**Consultation Response from KC,
Conservation & Design**
2022/91188 100, St John's Road, Birkby, Huddersfield, HD1 5EY
Erection of single and two storey side and two storey rear extensions to increase ground floor retail unit and HMO above (within a Conservation Area)
Date Responded: 10.06.2022
Responding Officer:
Responding Ref:

client	MR CHAHAL		
project	100 ST JOHN'S ROAD BIRKBY HUDDERSFIELD HD1 5EY		
drawing	PROPOSED PLANS AND ELEVATIONS		
revision	notes	date	drawn
*	*	*	*
scale :	1:50 & 1:100 AT A1	03.22	PB
project no.	drawing no.	revision	
2210	02

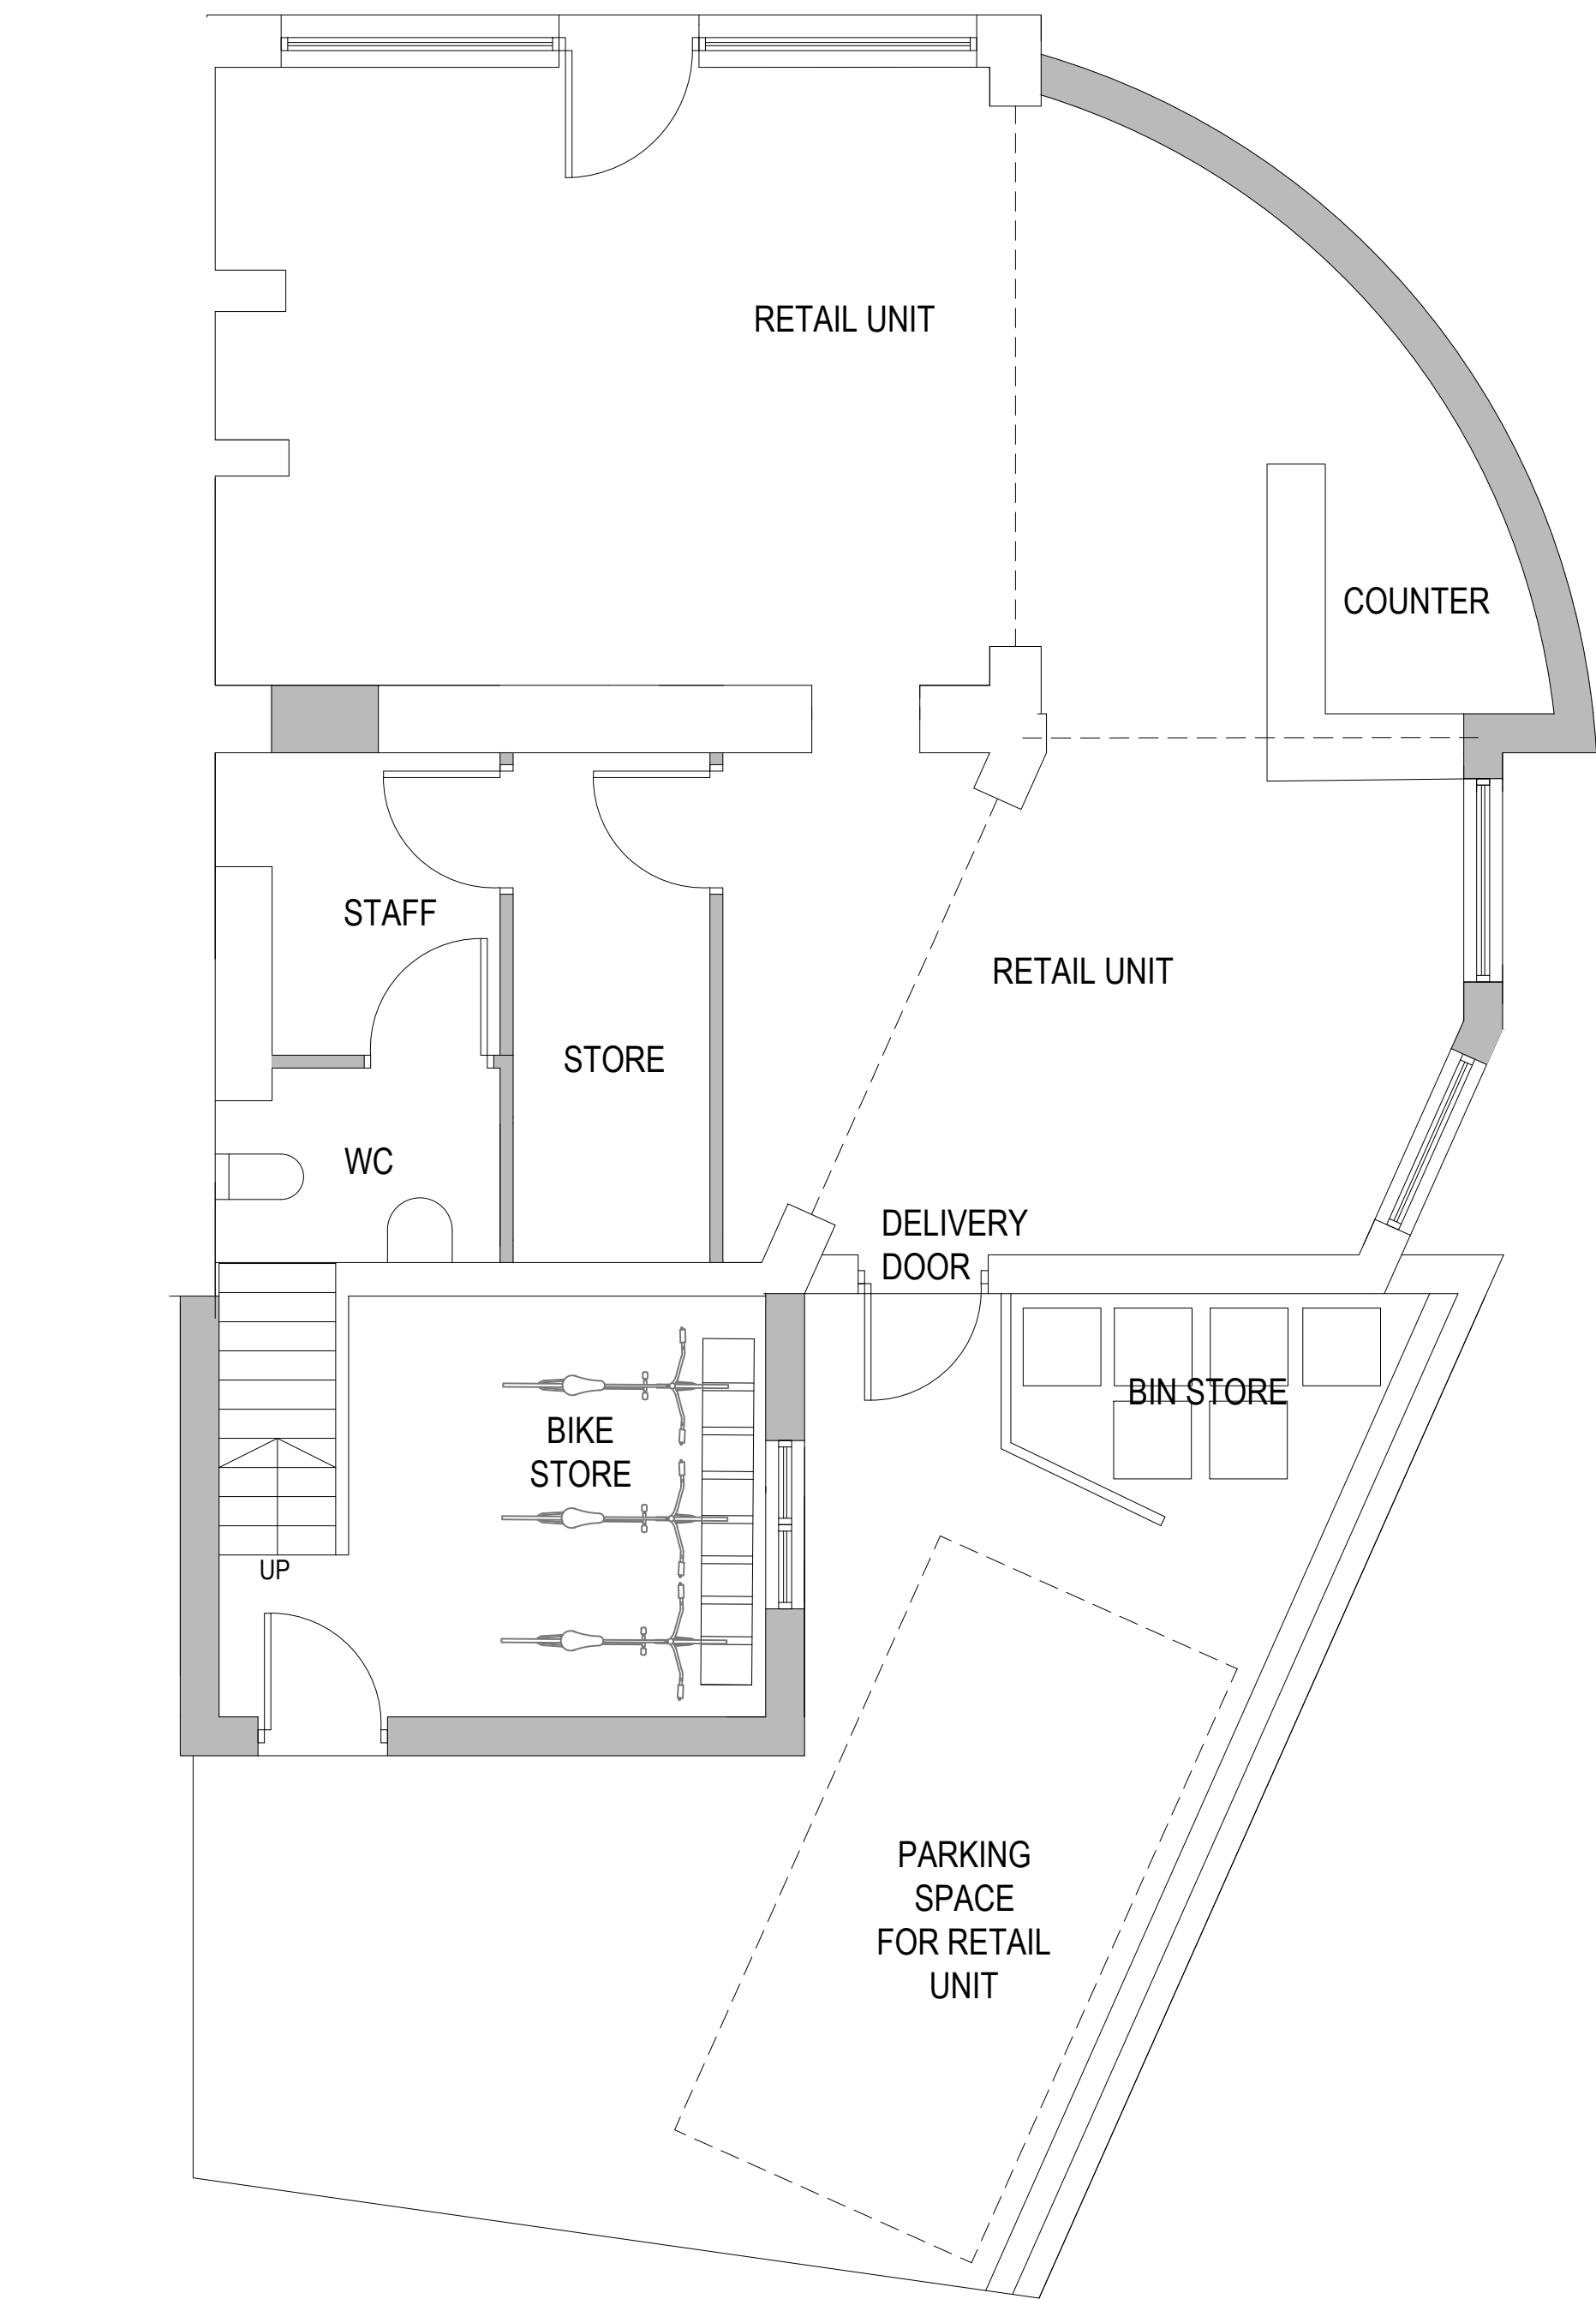
The proposals are for a single storey side extension and large two storey rear extension. Conservation do not support the proposals, which would see substantial development which would also see the loss of historic signage to the rear elevation, which as noted is a key part of the character of the building and area, a rare surviving example in the area. The development while making use of the similar materials does not consider the overall impacts to a key corner plot location.

We do not consider that the proposed development to be acceptable and would raise an objection. We do not consider the proposals to meet the requirements of Policy LP35 of the Local Plan. We also find the proposals to be contrary to Policy 72 of the Planning (Listed Building and Conservation Areas) Act. There is no convincing or compelling justification for the proposed works which would have a negative impact to the character of the building and Conservation Area with the noted loss of the historic possibly late 19th early 20th century signage, which has a strong contributing factor of the building. To reiterate we object to the proposed development.
